From: Julia Davies [REDACTED]
Sent: 15 January 2019 17:34
To: Zac Denton
Subject: 13 Grand Avenue (LU/321/18/HH)

Please find attached a set of revised plans and elevations for the loft conversion. Whilst I appreciate your request for a reduction in width and depth of the rear dormer, it is not possible to achieve the accommodation that the owners require with such a significant loss of floor space.

(Attached drawings P01b and P02a to be substituted for drawings P01a and P02 respectively)

Proposed Loft Conversion
at 13 Grand Avenue, Littlehampton
for Mr P Pedzinski & Ms P Marsh
Drawing P01b October 2018 Scale 1:100 @ A3
Planning Drawing - Plans and Elevations

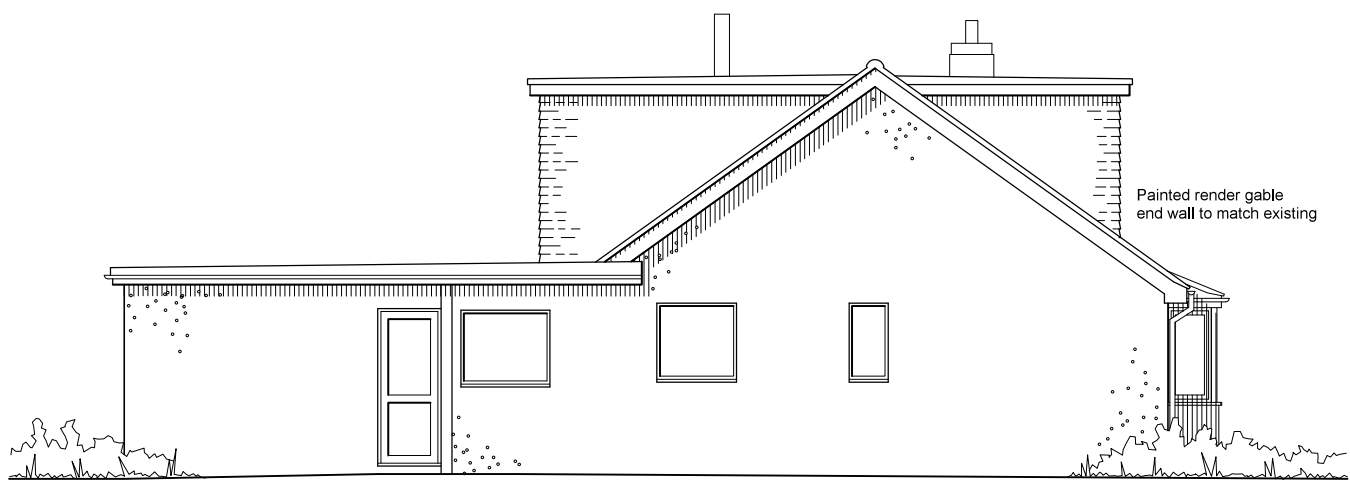
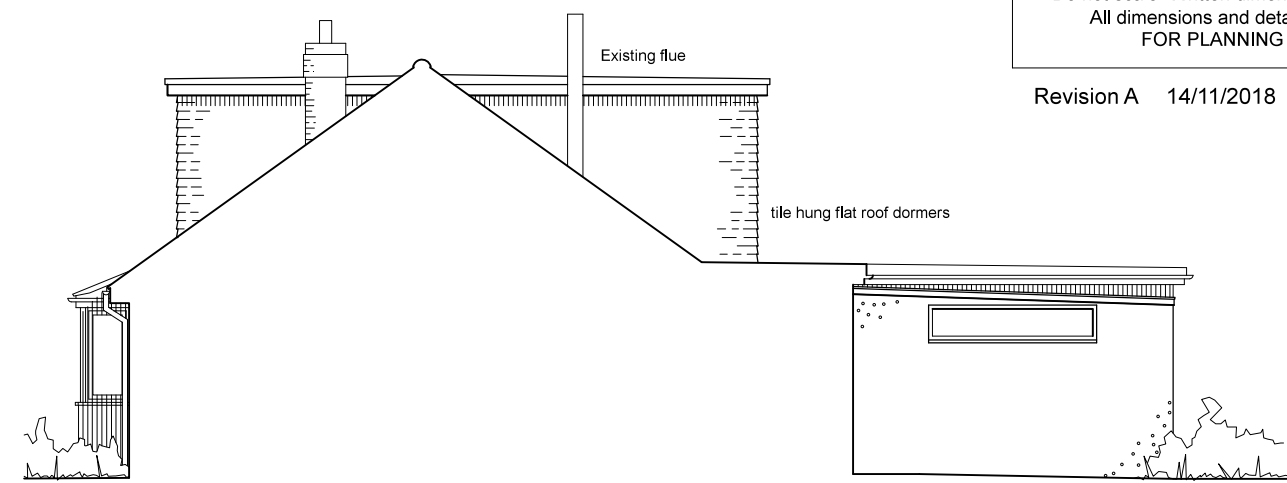
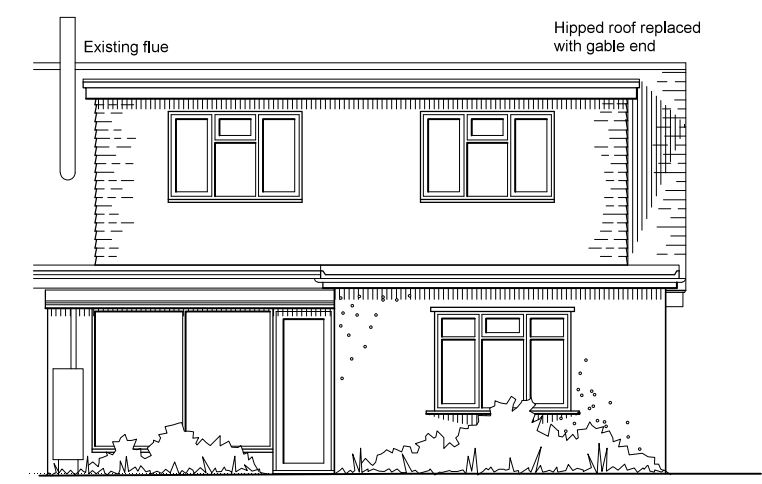
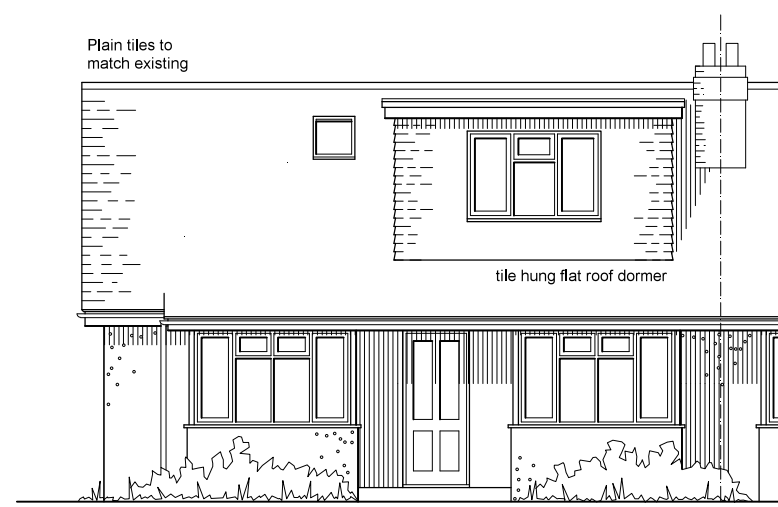
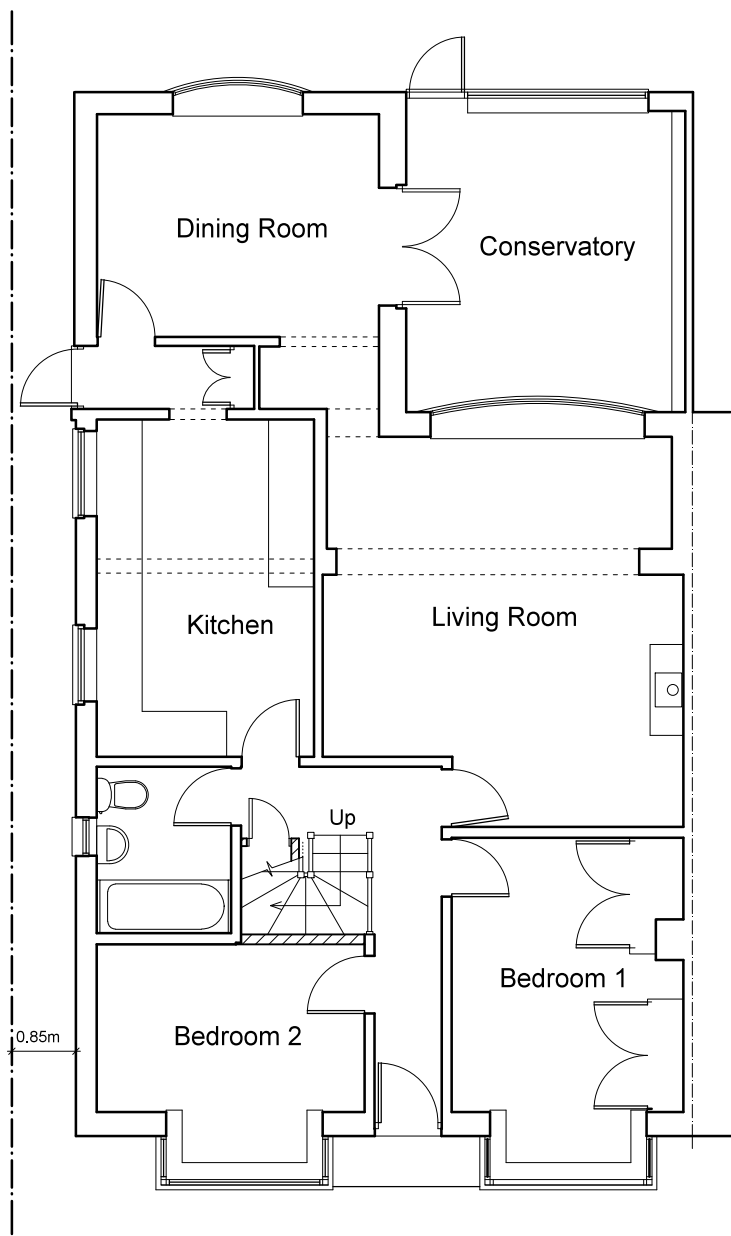
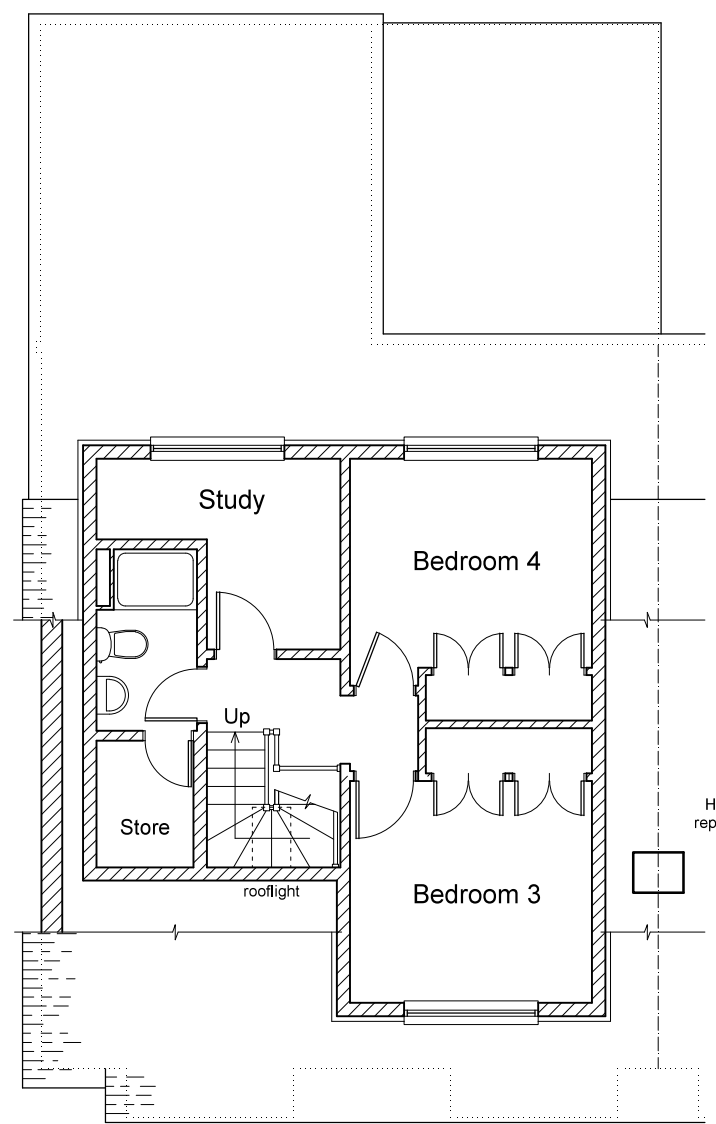
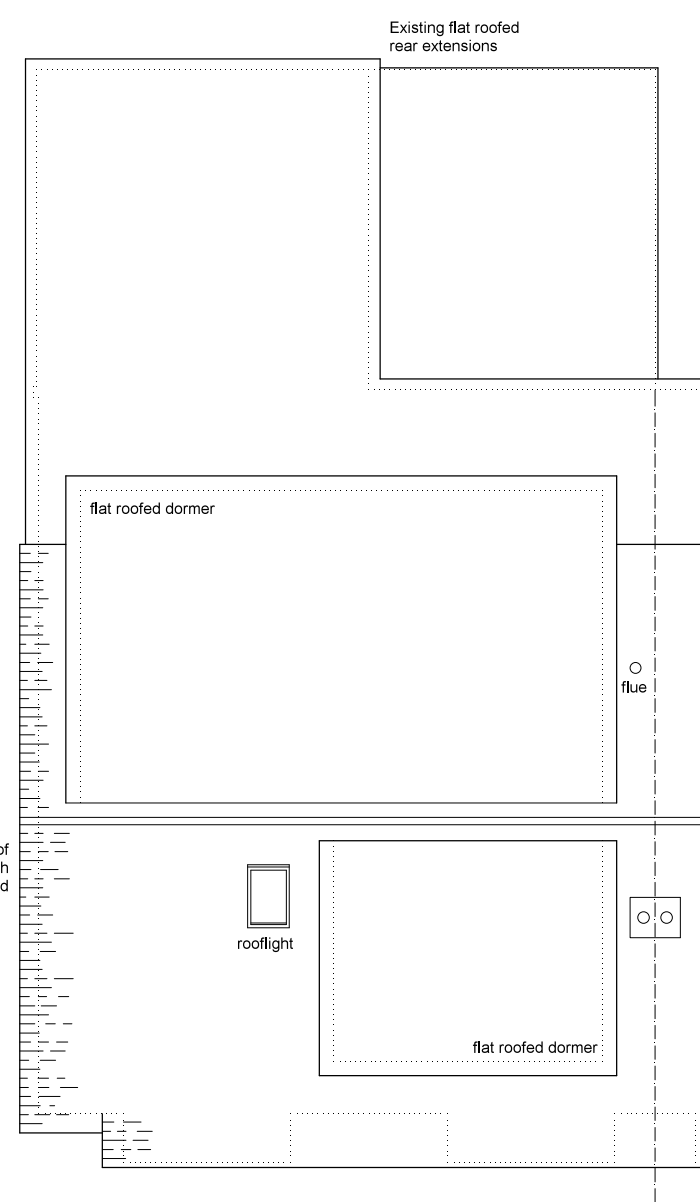
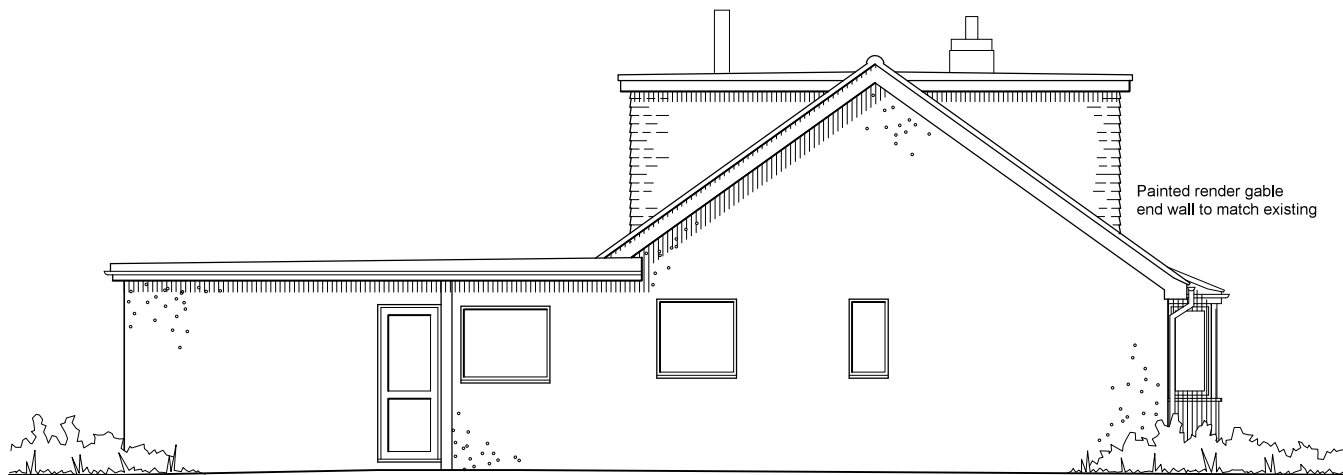
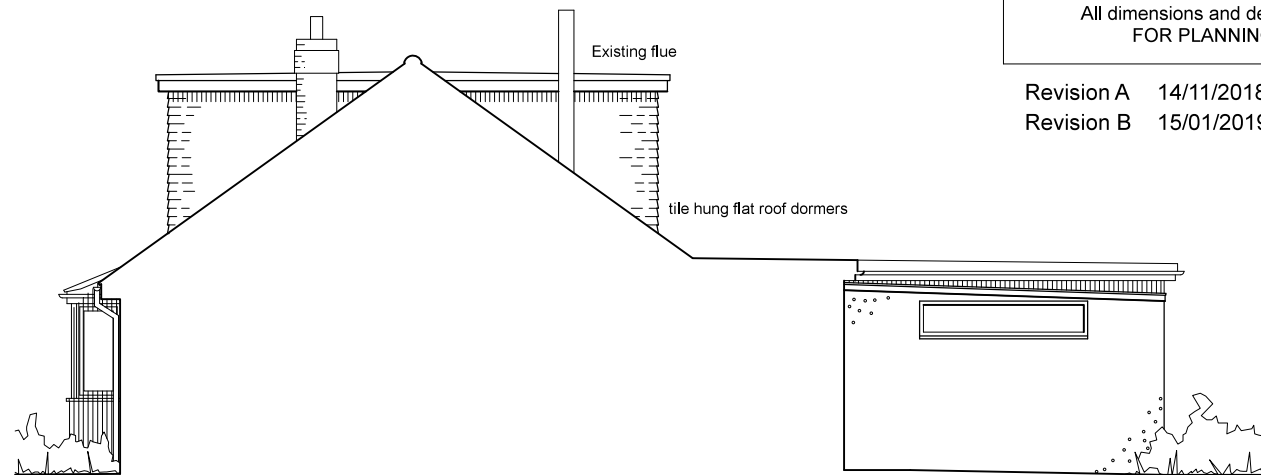
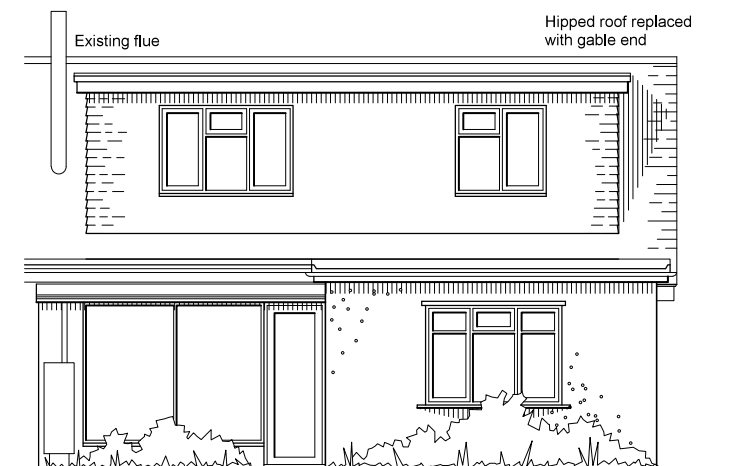
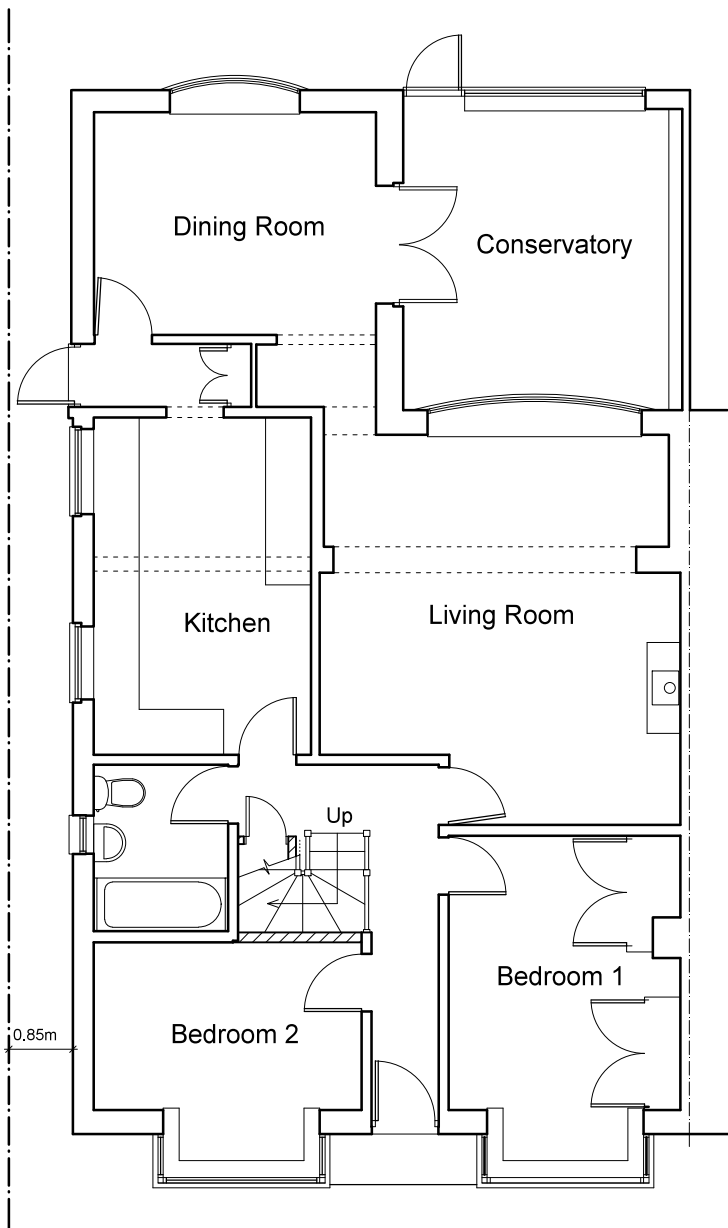
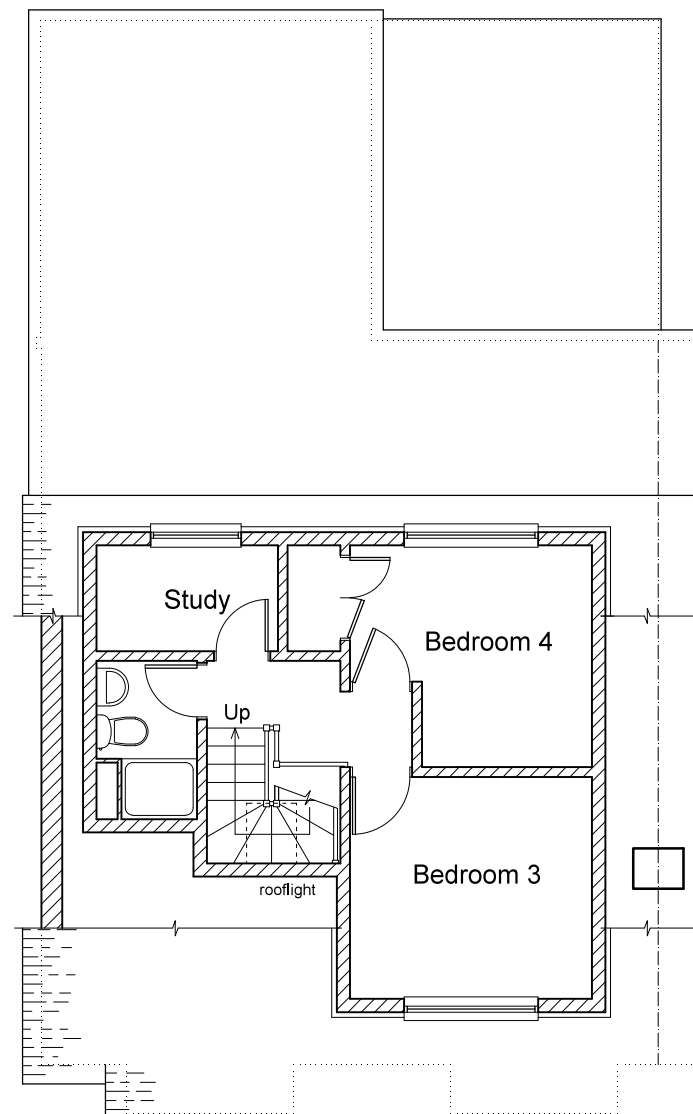
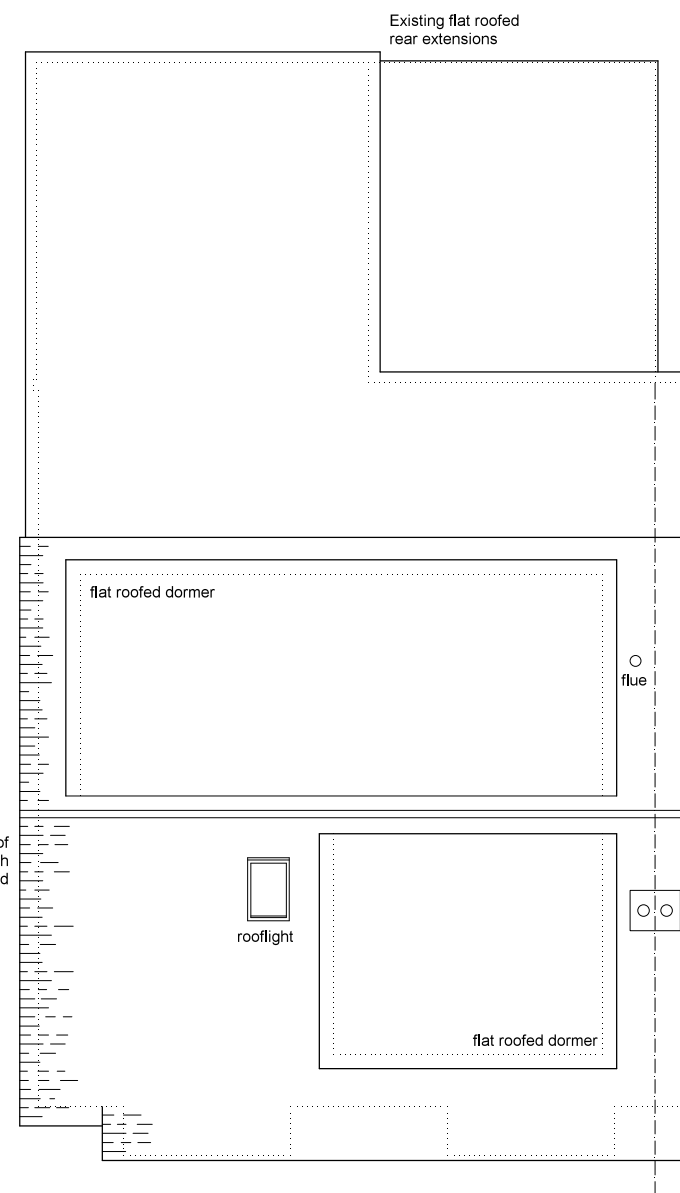
In light of this, I have moved the rear wall of the dormer back 1.2 metres, so that it is no longer behind the rear wall of the original property. However I have maintained the width as originally proposed. The western wall is already set back from the party wall line; research of similar properties in the immediate area showed that there are other properties that have had a full width dormers approved for both the front and rear of the roof.
